**Re: Stone Age Climbing Gym**  
**6110 Alameda NE**  
**60-Day Temporary Certificate of Occupancy**  
**Transportation Development Final Inspection**  
Engineer's/Architect's Stamp dated 4-23-19(DRB) (C18D086A)  
Certification dated 7-31-20

**RE: STONE AGE CLIMING GYM PERMIT NUMBER BP-2019-33977  
TRAFFIC CERTIFICATION FOR PERMANENT CERTIFICATE OF OCCUPANCY  
RESPONSES TO COMMENTS:**

Overall Site Plan

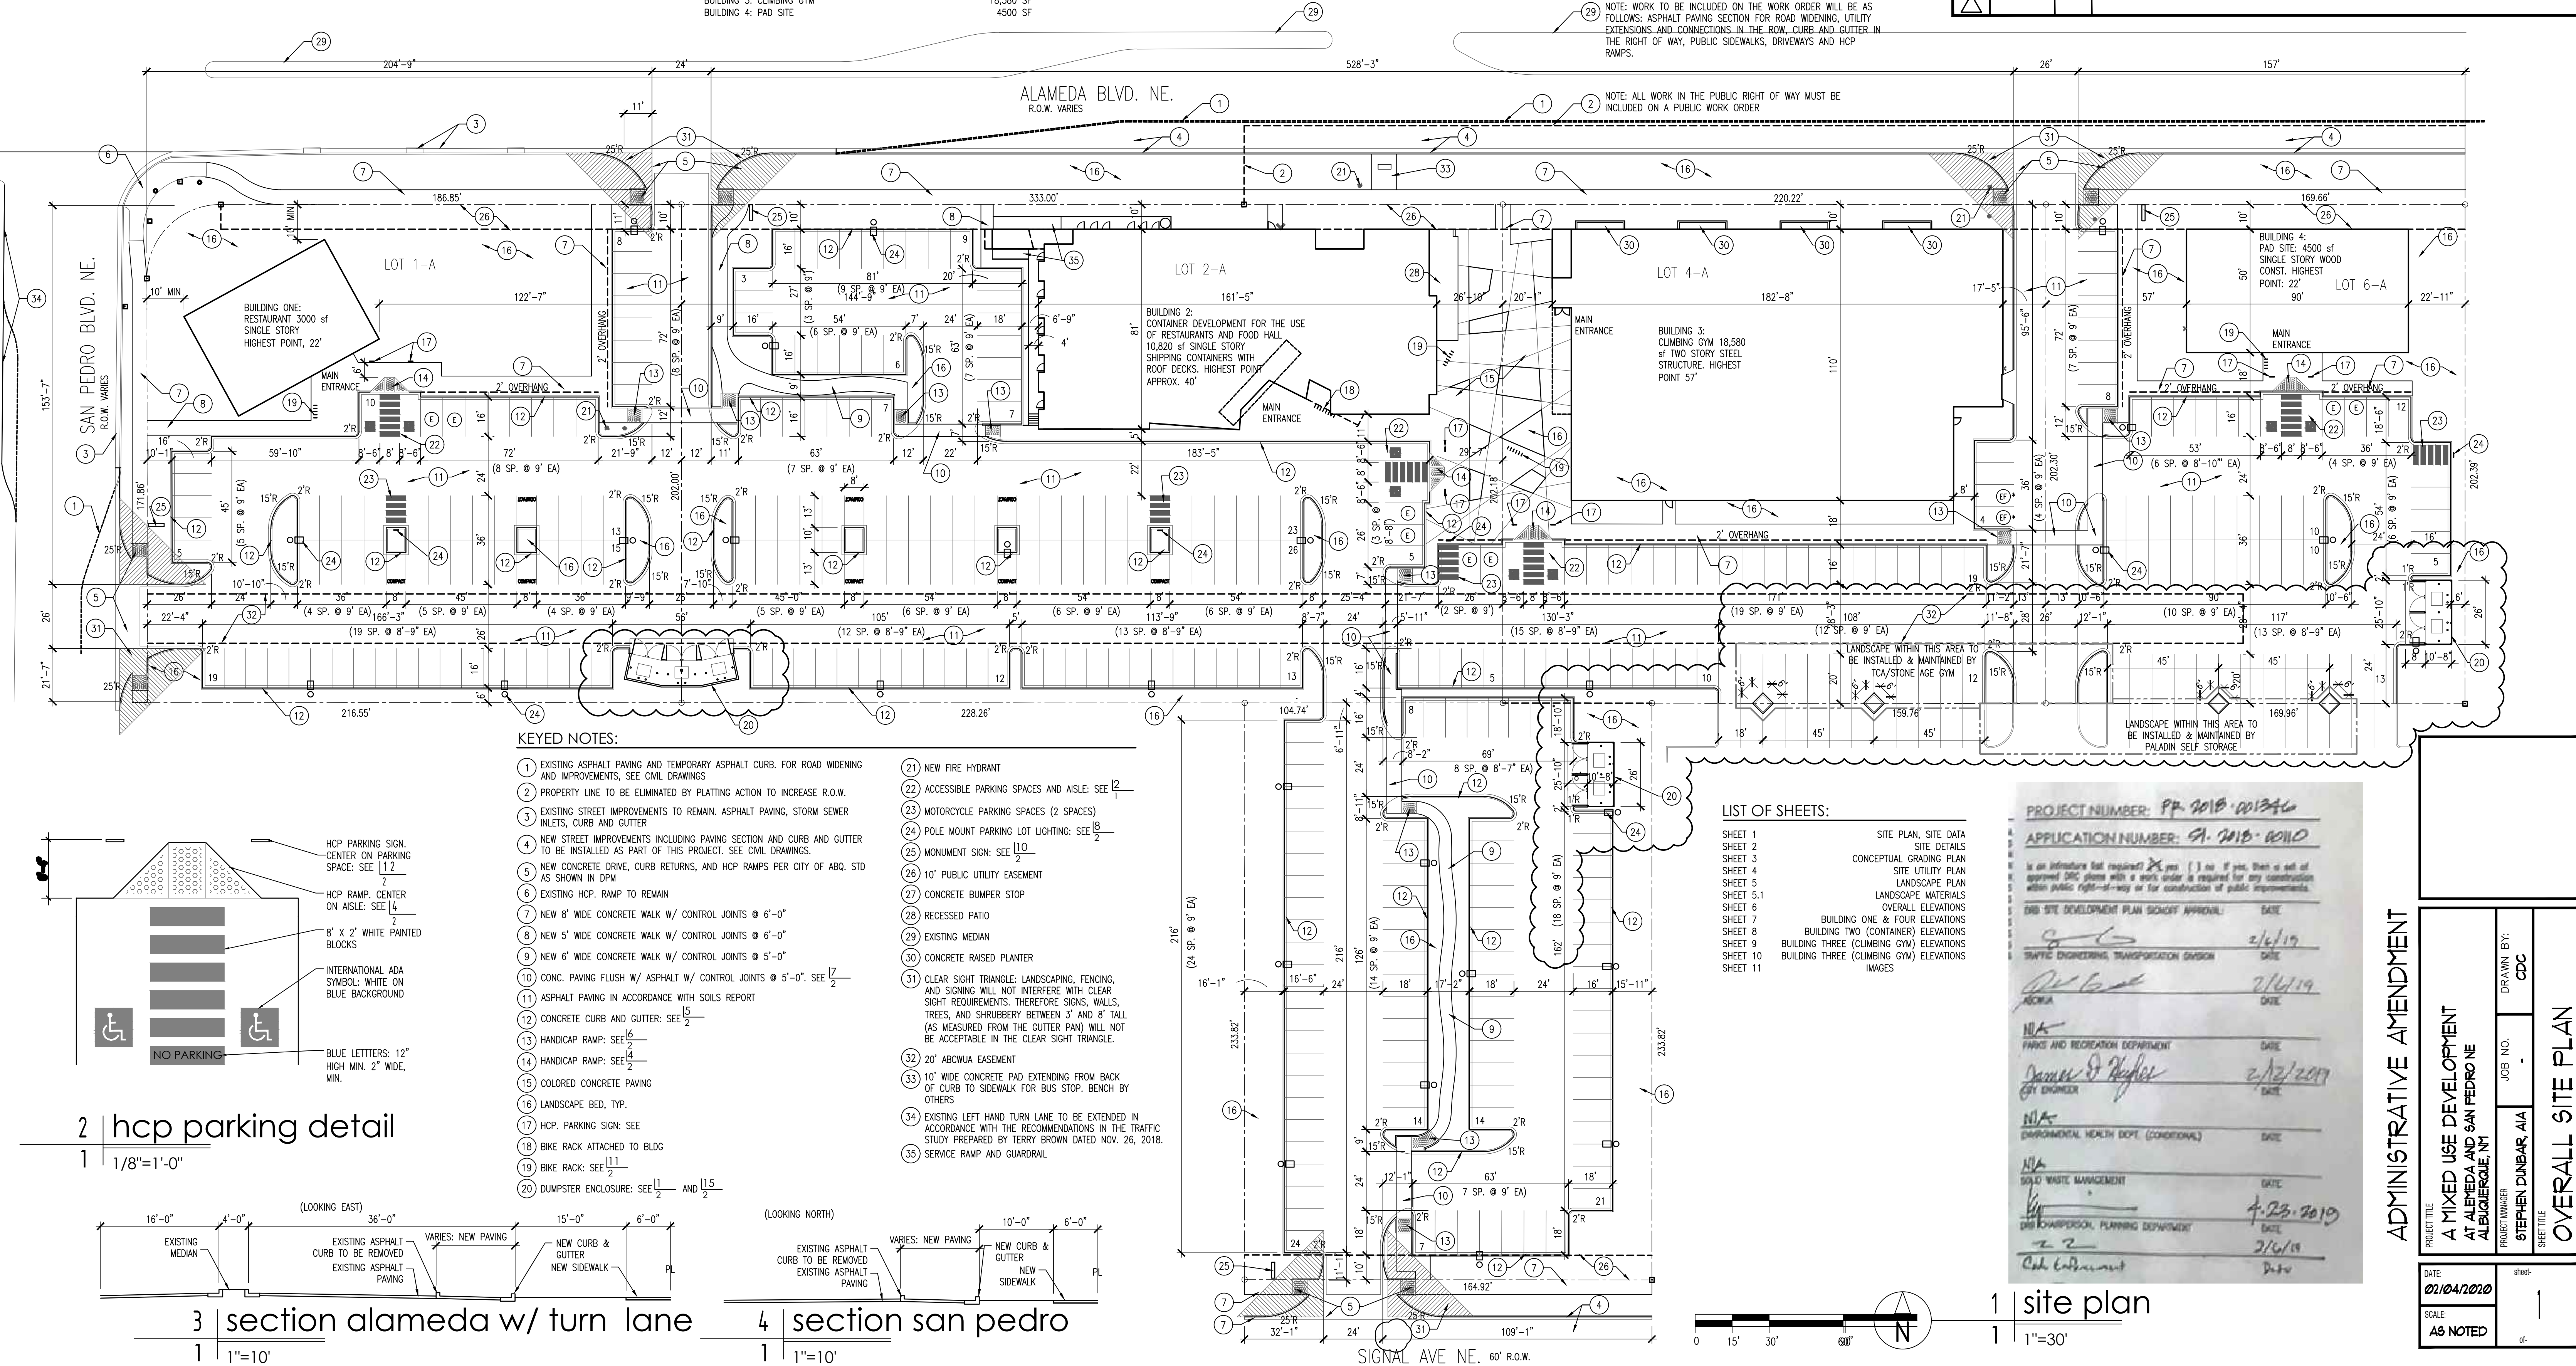
- 60 day TEMP CO based on further coordination with the City to get correction items addressed.

This letter is to acknowledge the comments given to us by Nilo Salgado, Ernie Gomez and Jeanne Wolfenbarger of the Transportation Department regarding the accessible path requirement between Stone Age Climbing Gym and Tin Can Alley. We are proposing a new ramp to be installed by means of two compliant handrails at a location adjacent to the Stone Age handicap parking stalls at a location which complies with slope requirement in all directions. Furthermore, we propose to provide a temporary barricade adjacent to the Stone Age handicap spaces that will direct disabled patrons to the Stone Age entrance only. This barricade would be removed once the permanent handrails are installed.
